Ribchester Parish Council

PLANNING APPLICATION No: 3/12/0294 and 295

Application: Proposed demolition of single storey extension to be replaced with a two storey extension [resubmission]

At: 12 & 13 MANOR AVE. RIBCHESTER

Scale 1:200

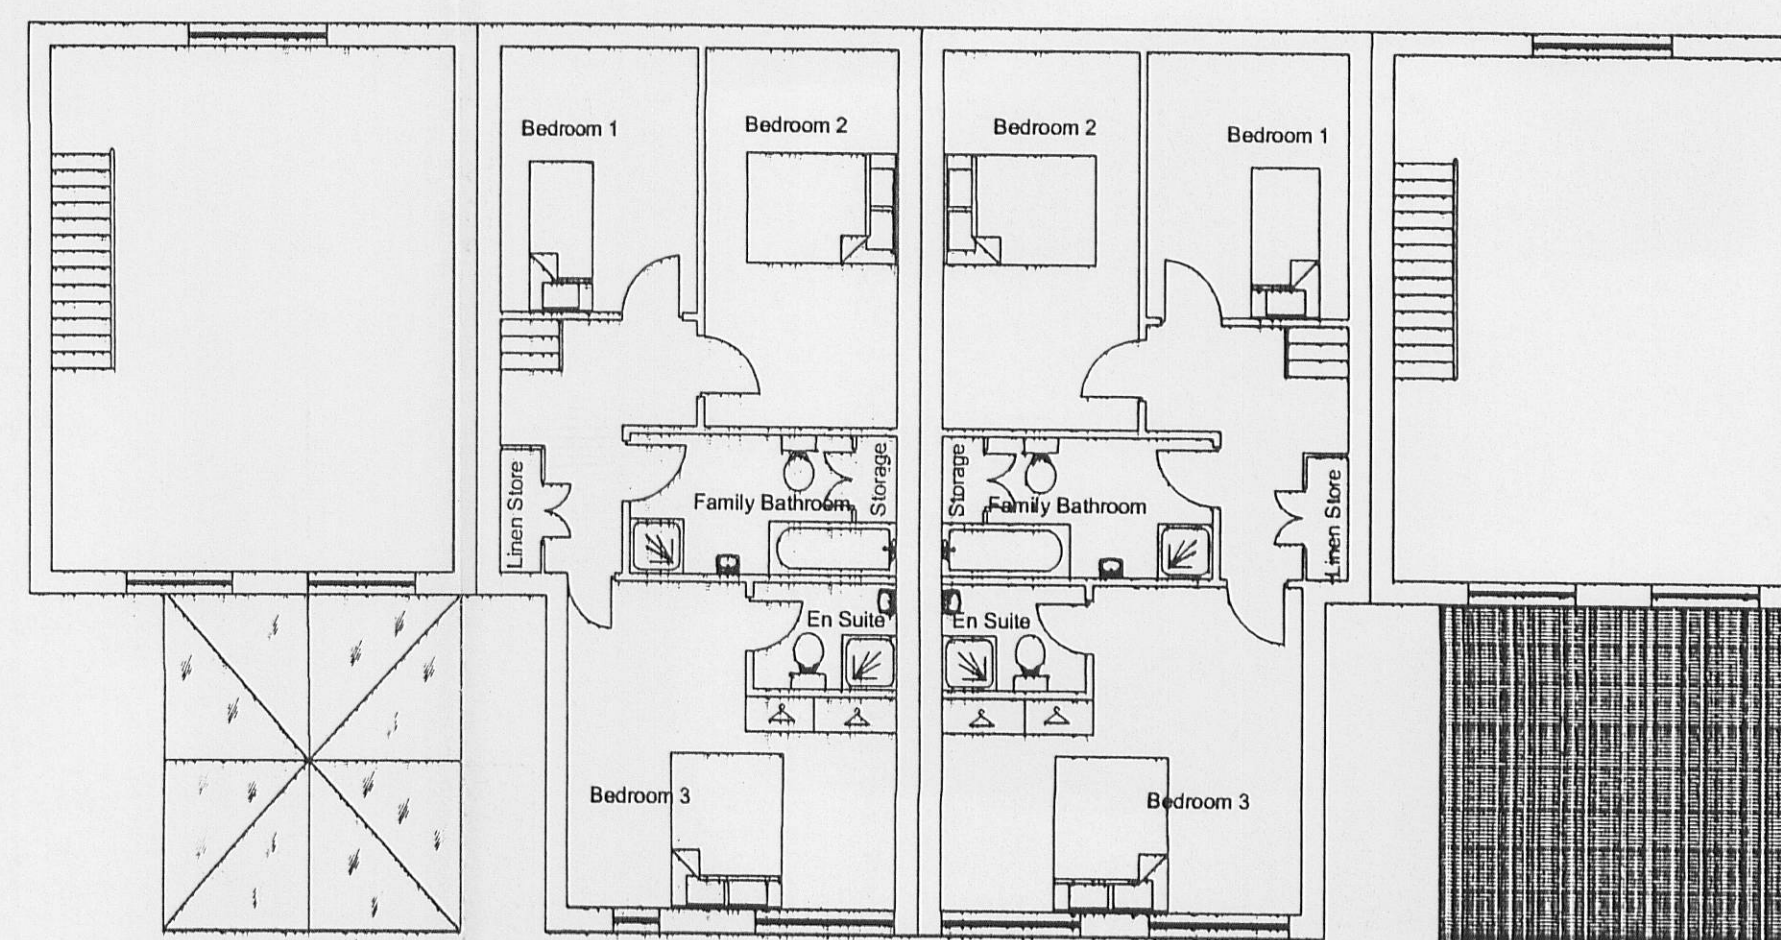
The Parish Council notes that the two original applications were refused by planning officers on the grounds that the proposals were harmful to the amenity of neighbouring residents as a result of the overbearing nature of the developments and the loss of light. The present applications as now submitted show such minimal adjustments to dimensions that the initial conclusion remains pertinent.

While the Parish Council did not object to the original applications it now takes the view that the proposals would result in significant harm to the amenity of neighbouring properties and, therefore **OBJECTS** to the applications.
